From: [Mau, Russell E \(DOH\)](#)
To: [Chace Pedersen](#)
Cc: [Holly Erdman](#); [Smits, Brenda M \(DOH\)](#)
Subject: RE: SE-23-00009 Nelson View - Notice of Application
Date: Thursday, April 20, 2023 10:52:31 AM

RE: SE-23-00009 Nelson View

SUBJECT: WDFW COMMENTS ON SE-23-00009 NELSON VIEW SUBDIVISION

TO: All Staff
FROM: Public Works Plan Review Team
DATE: May 8th, 2023
SUBJECT: SE-23-00009 Nelson View

Figure 1. LiDAR imagery of the channel scar through the project area, west of Big Creek.

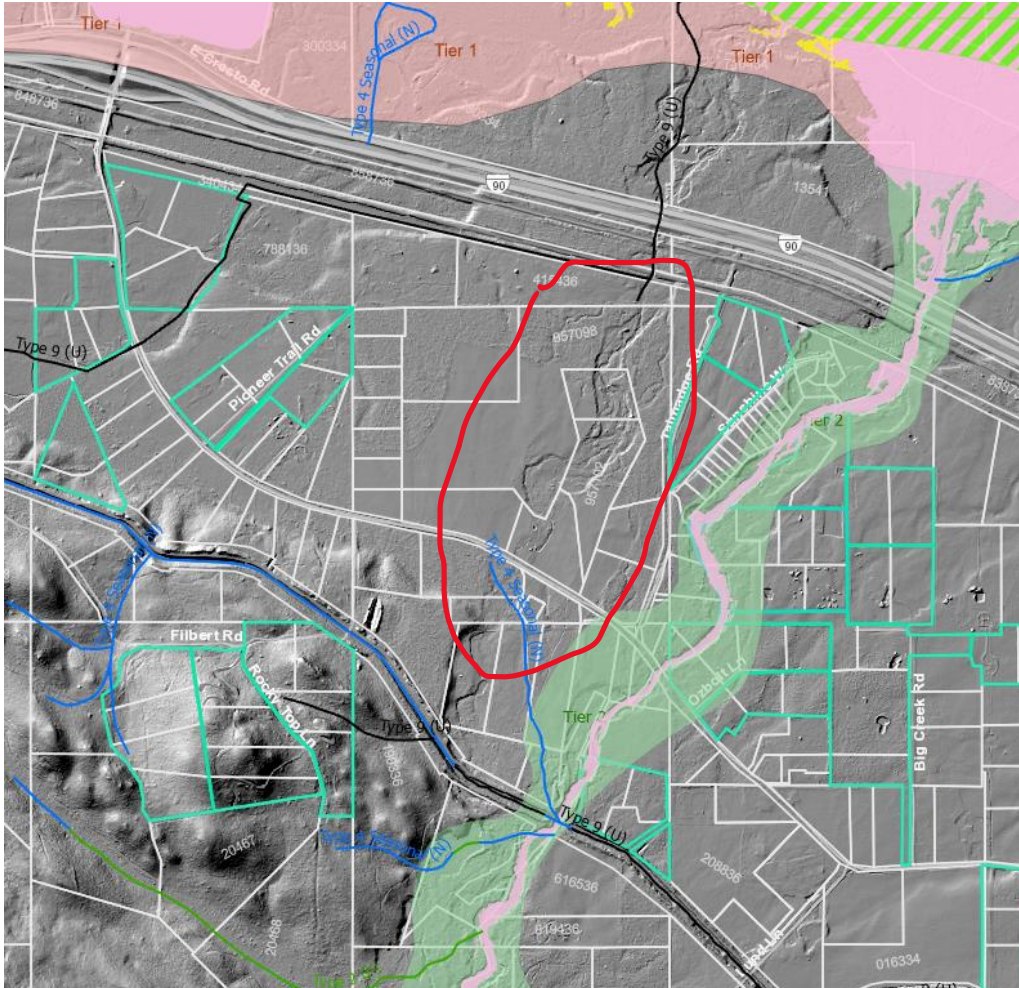
While the project area is not immediately adjacent to Big Creek, the LiDar clearly shows a relic channel through several of the proposed lots (Figure 1), specifically lots 6, 9, and 10. If you follow the scar upgradient, it may be that this scar represents the historic irrigation channel, that was likely an old Big Creek channel in geologic time. Where this channel appears to start is just south of the KRD's canal and within the mapped Channel Migration Zone for Big Creek. This could result in channel avulsions or flood flow conveyance through the relic channel that the proponents/owners should be made aware of, despite not being mapped as a special flood hazard area by FEMA.

- A critical areas report should be submitted for the project because there appear to be potential wetlands present and there are untyped streams present at the northern portion of the property. The critical areas report should also cover the geological hazards associated with the channel migration zone along Big Creek that may result in flow entering the channel scar through the project area. This project area is mapped as a Tier 1 for Critical Aquifer Recharge Area as well. The Critical Areas report should address all 5 critical areas that may be present or near the project area. The untyped stream mapped at the northern extent of the property appears to have conveyance infrastructure through the railroad grade and Interstate 90, connecting it to the Yakima River. This channel may provide fish habitat and warrants further investigation.
